**Fraser Drive, South Tweed Subdivision (MP 06_0243 Mod 5)
Response to Submissions**

ATTACHMENT A – ISSUES RAISED BY THE DEPARTMENT

LOT LAYOUT AND
STAGING PLAN

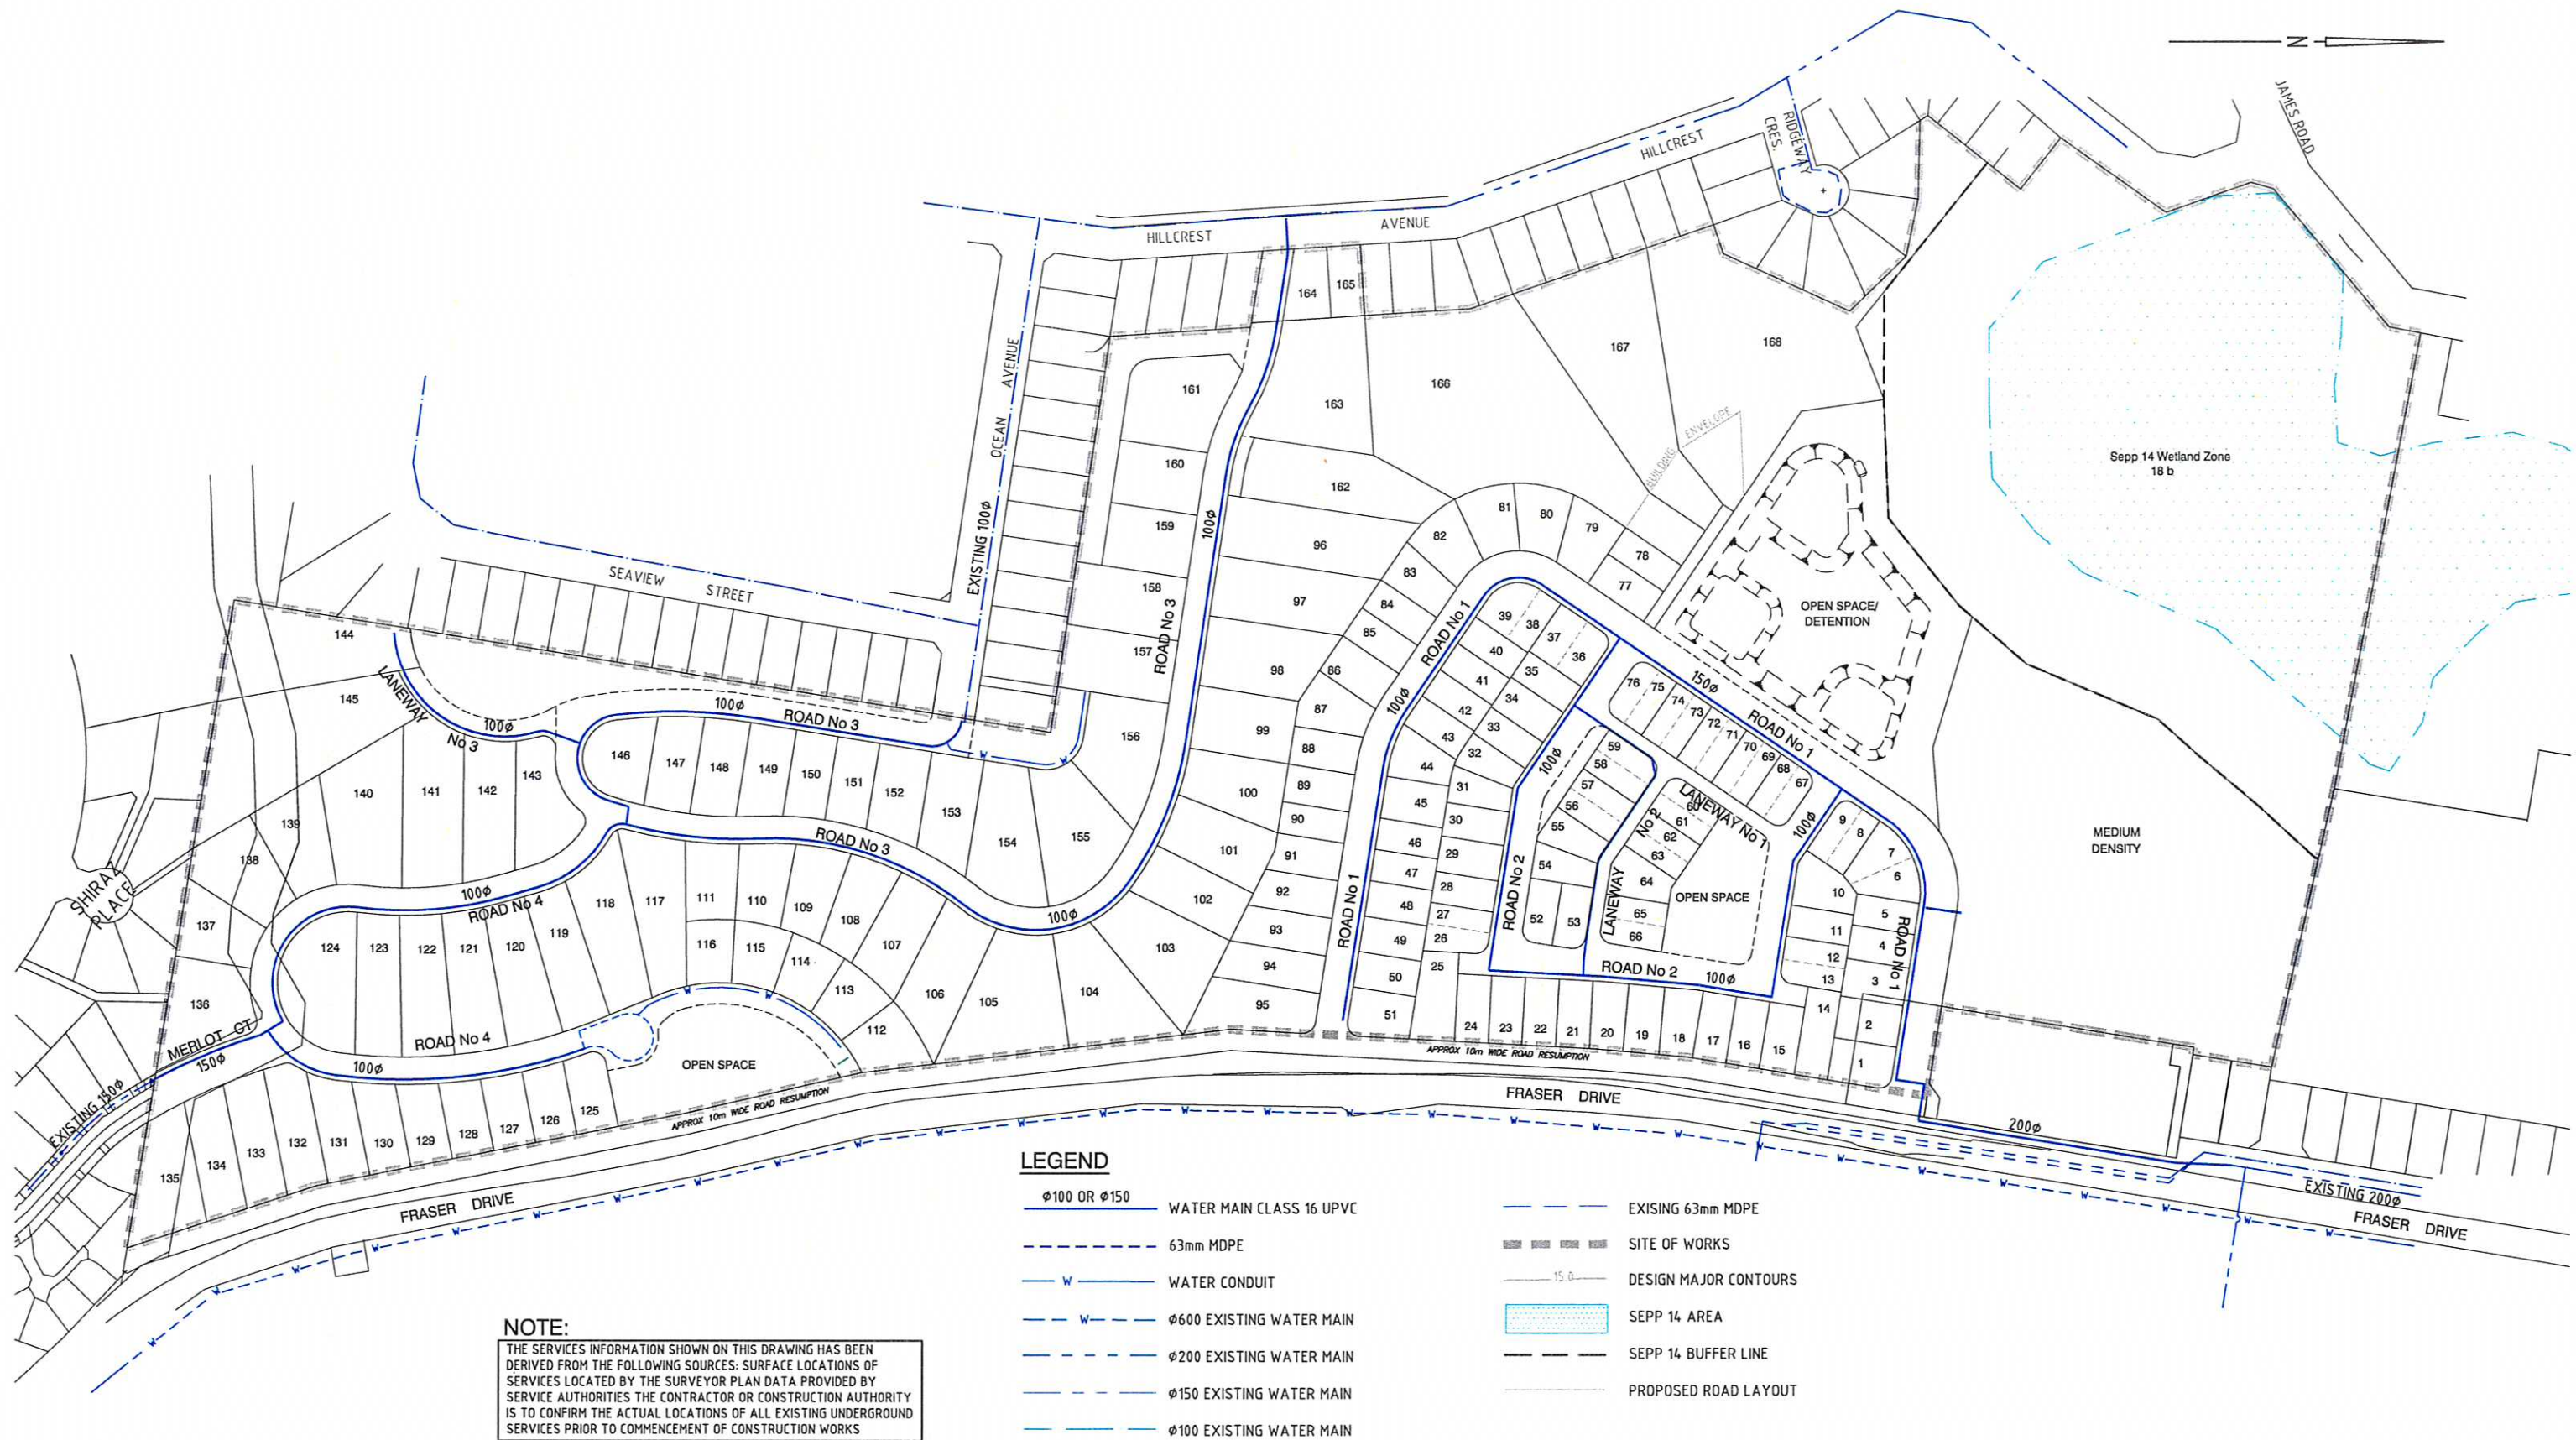
- The subdivision design should be amended to remove battle-axe lots where possible, to maximise lots with street frontages for waste collection and minimise the requirement for rights of carriageway.

- The provision of essential infrastructure such as bus stops and stormwater detention linked to Stage 16 is not supported. These works should remain linked to multiple stages, earlier than stage 16, to ensure they are delivered in a timely manner.
